**KIRKLEES METROPOLITAN COUNCIL  
INVESTMENT & REGENERATION SERVICE**

**DELEGATED DECISION TO DETERMINE APPLICATIONS FOR  
CONSENT, AGREEMENT OR APPROVAL REQUIRED BY CONDITION**

Reference No:	<b>2024/44/92255/E</b>
Site Address:	Oakwood House, Lane Head Lane, Kirkburton, Huddersfield, HD8 0SQ
Description:	Discharge of details reserved by Conditions 4. (Arboricultural Method Statement) & 5. (materials) of previous permission 2022/93941 for Erection of extension and alterations to dwelling, erection of detached garage and detached garden room/gym (within a Conservation Area)
Recommending Officer:	Nina Sayers

**DECISION – DISCHARGE OF CONDITIONS 4 & 5**

Appendix 2: Tree Protection Plan

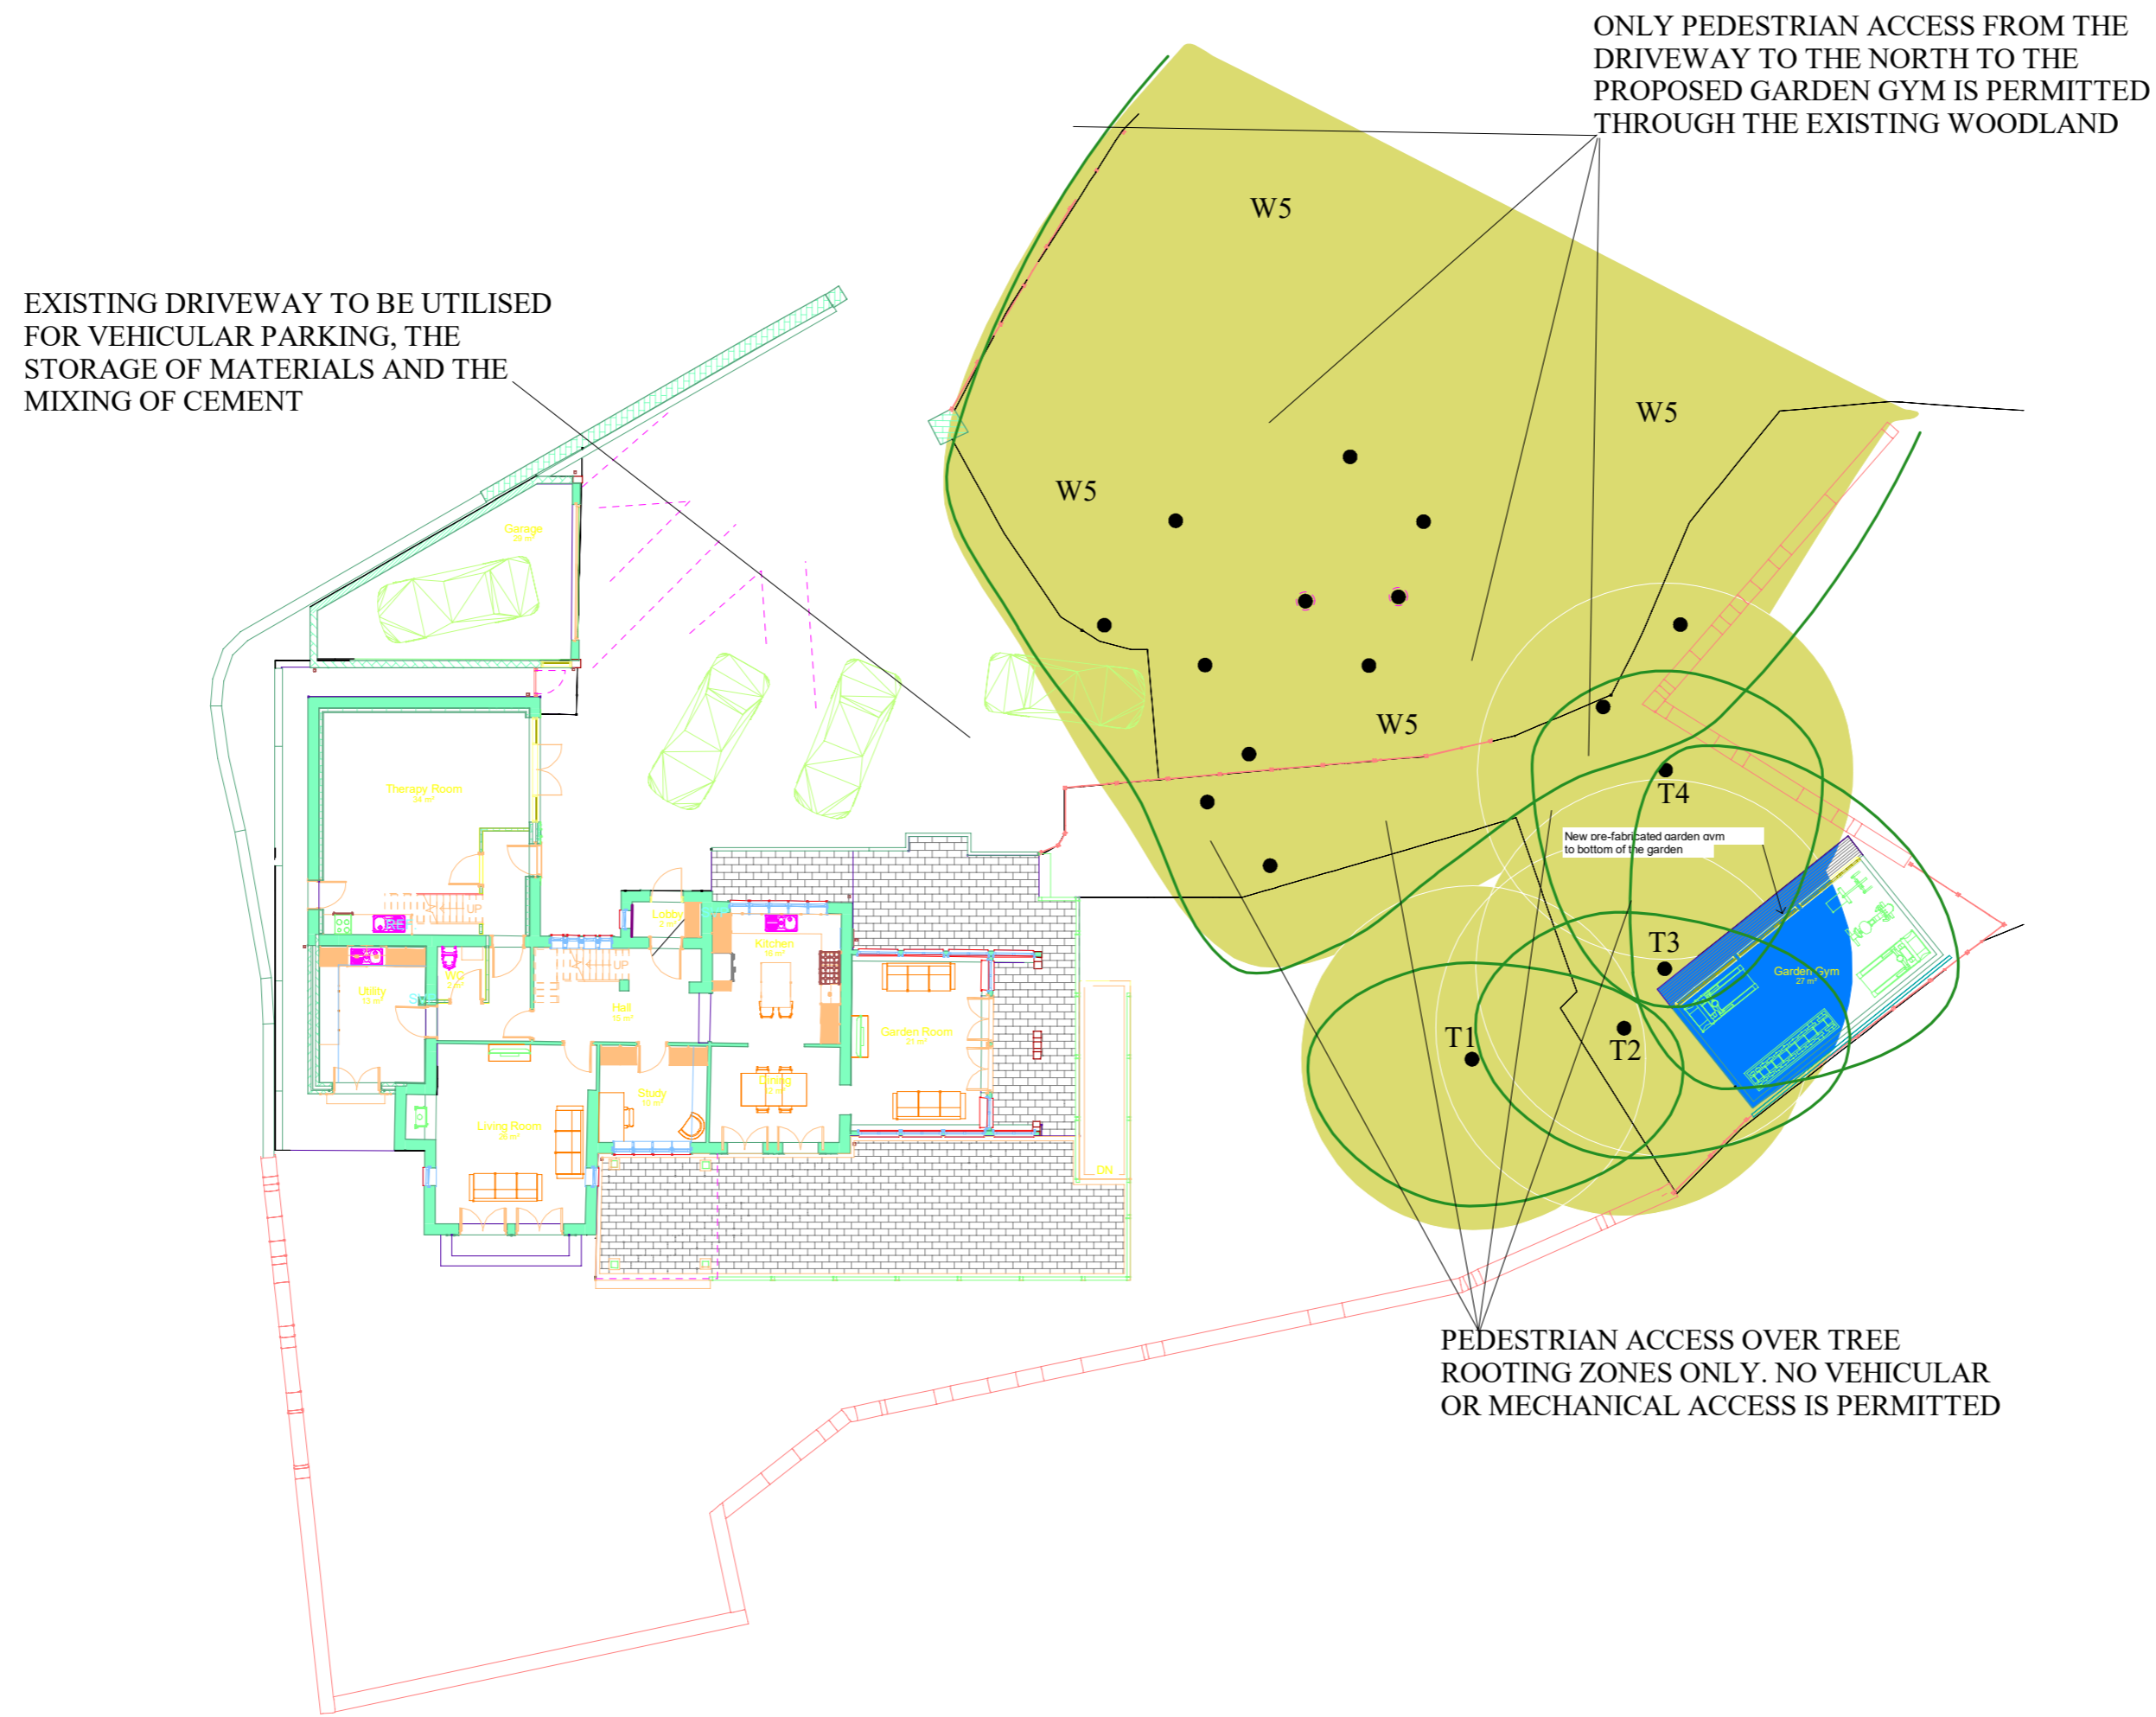
In support of the discharge of condition 4, the applicant has submitted an Arboricultural Method Statement (AMS) Ref: '20697/AJB'. KC Trees have reviewed the submitted AMS. It sufficiently details the special engineering techniques proposed to have minimal impact on surrounding trees. It is also laid out that only pedestrian access will be granted surrounding the trees and that all material storage of chemical mixing will be done outside on the RPA of trees and on the driveway adjacent. Therefore KC Trees have no objection to the discharge of condition 4.

Condition 4 can therefore be discharged. The development shall hereafter be carried out in complete accordance with the Arboricultural Method Statement.

Client	MILES HUSH
Project	ADAPTION/EXTENSION
Address	Oakwood House, Lane Head Lane, Kirkburton, Huddersfield, HD8 0SQ
Scales	Date
As indicated @A1	
Drawing Title	Garden Room Layouts
Drawing No.	7880 - X16
Revision	D

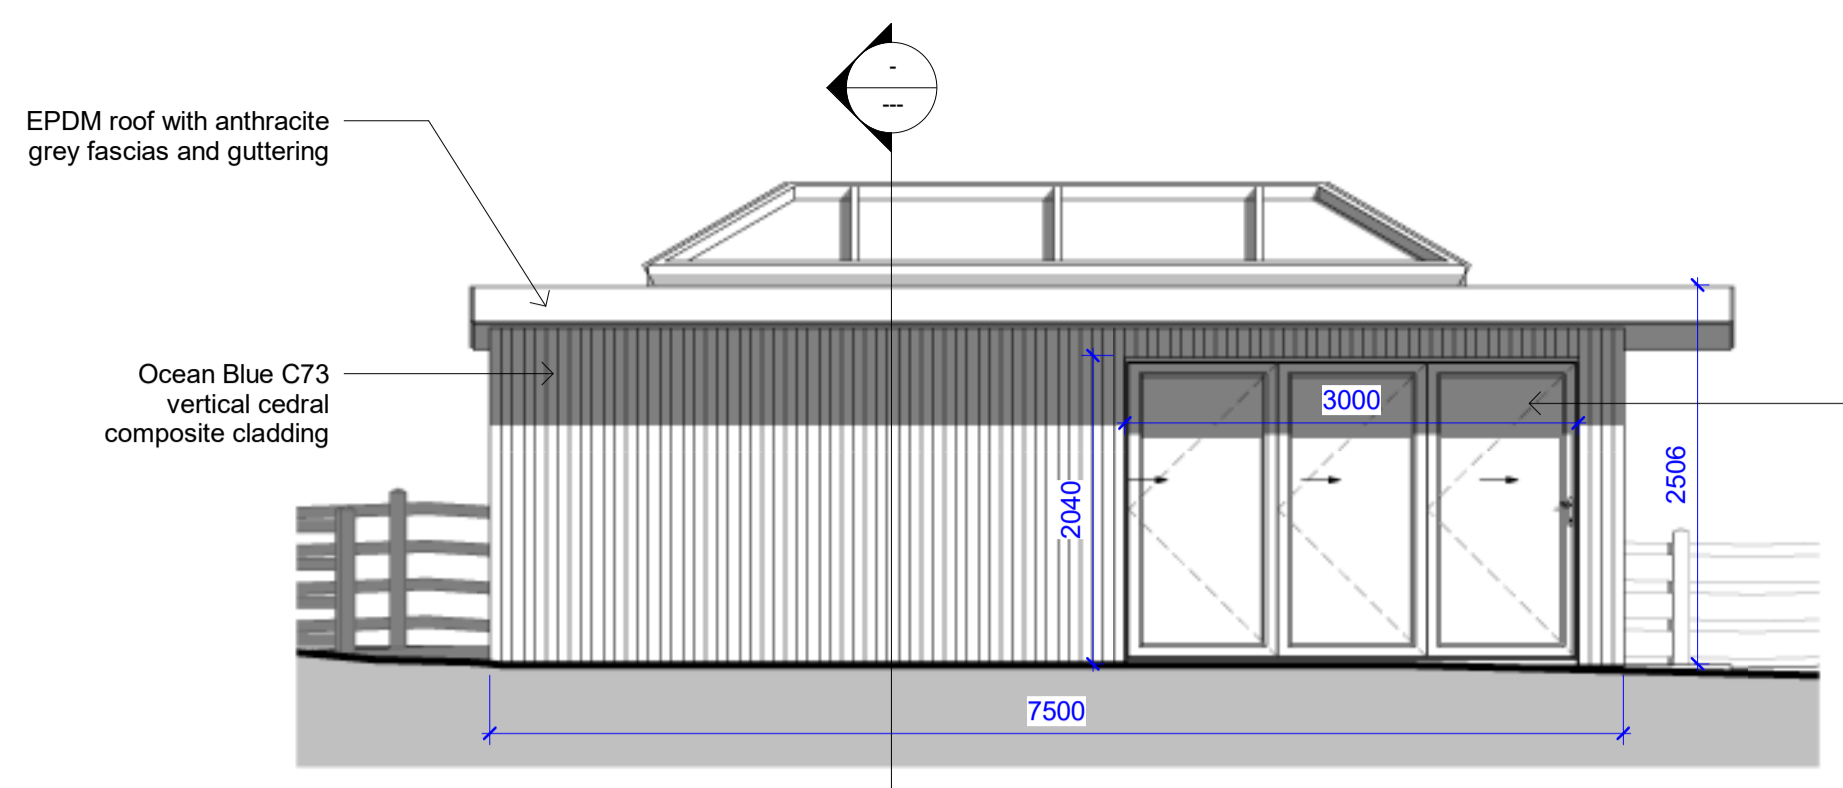
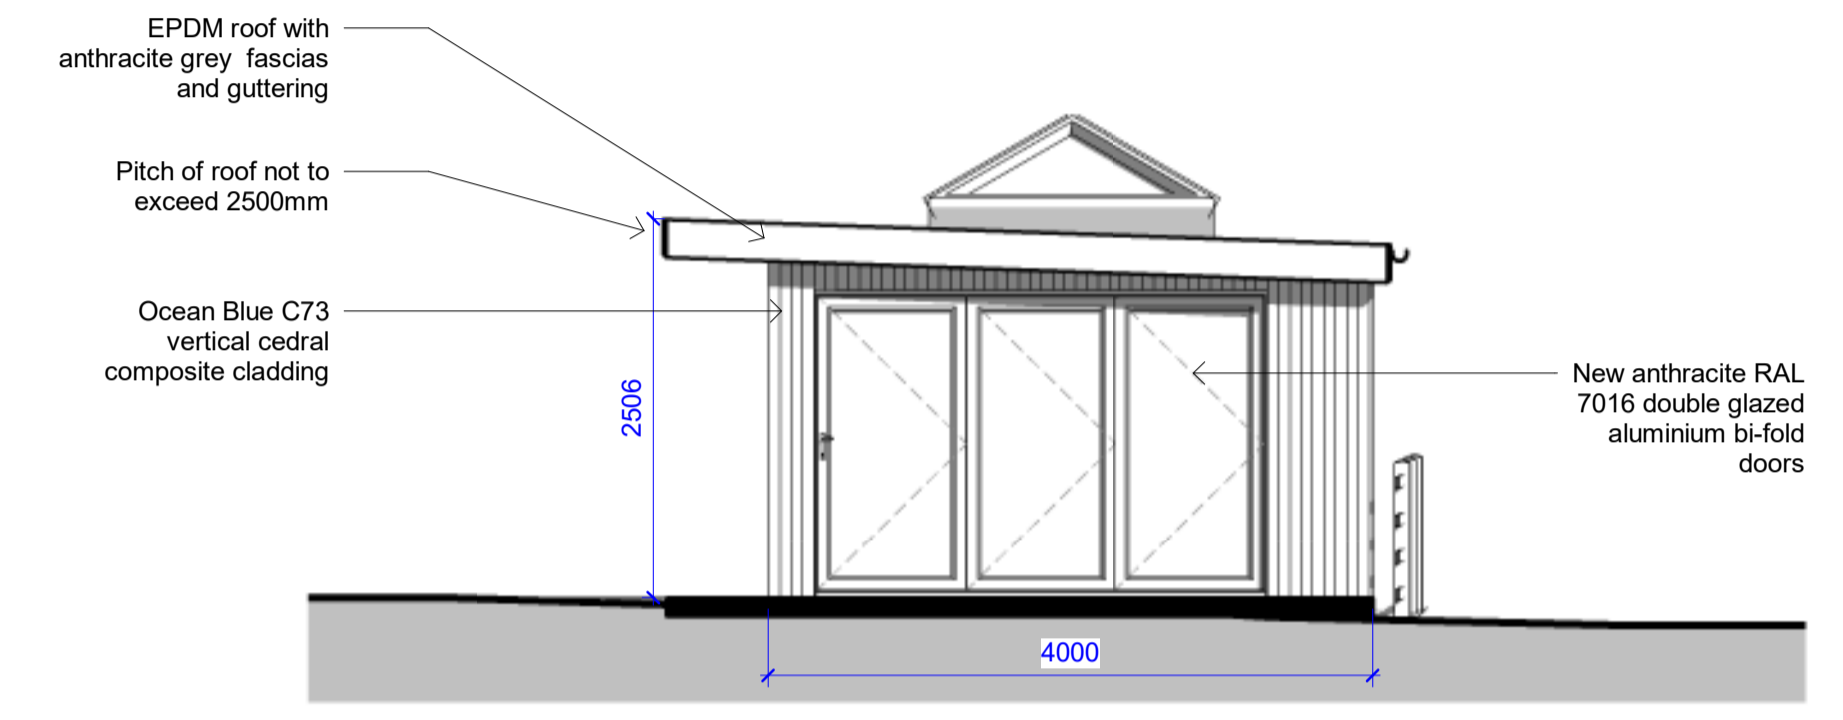
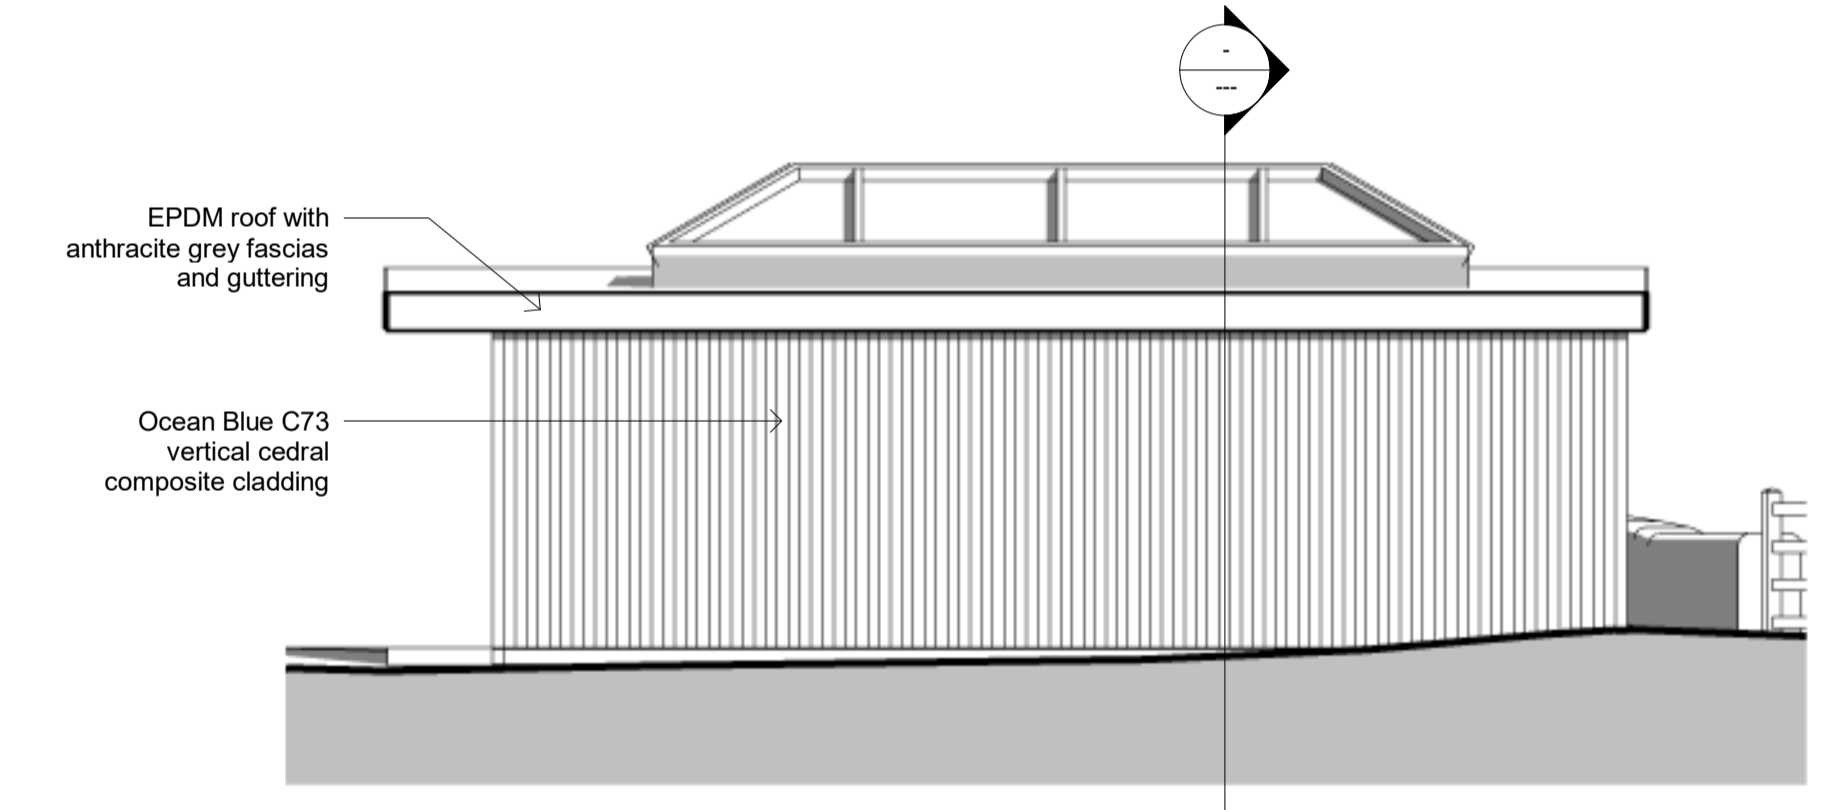
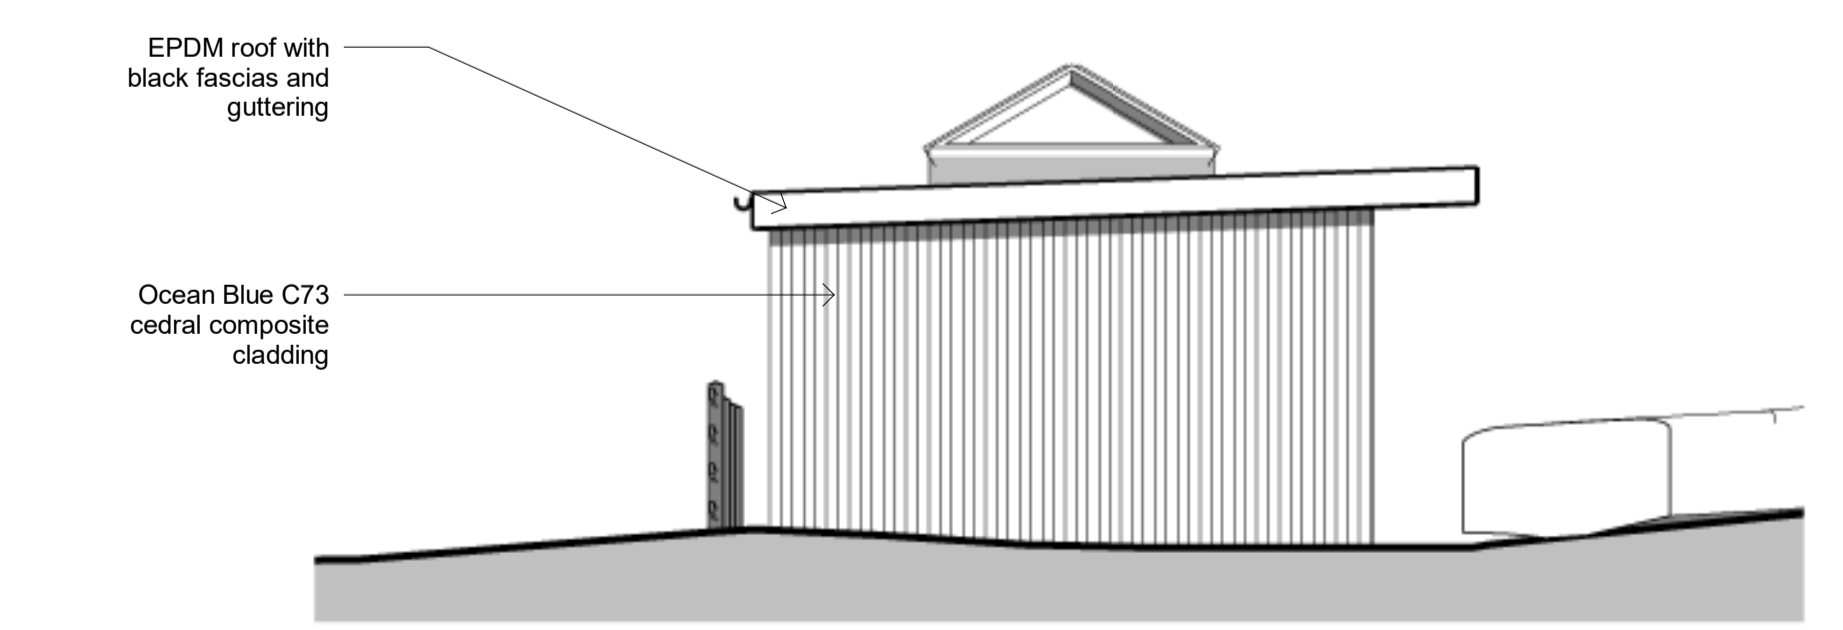
In support of the discharge of condition 5, the applicant has submitted Garden Room Layouts Plan Ref: '7880-X16 Rev.D'. The demonstrates the following materials:

- Ocean Blue C73 Vertical Cedral Composite Cladding
- EPDM roof with Anthracite Grey fascias and guttering

Officers initially queried the colour of the proposed cladding, however the agent responded showing photograph of the dormers and windows at the existing property which are finished in the same colour. Taking this into consideration, as well as the garden room being screened from any vantage points within the conservation area, it is considered the proposed materials are acceptable on balance.

Therefore condition 5 can be discharged at this time. The development hereafter shall be carried out in accordance with the approved details and retained as such.
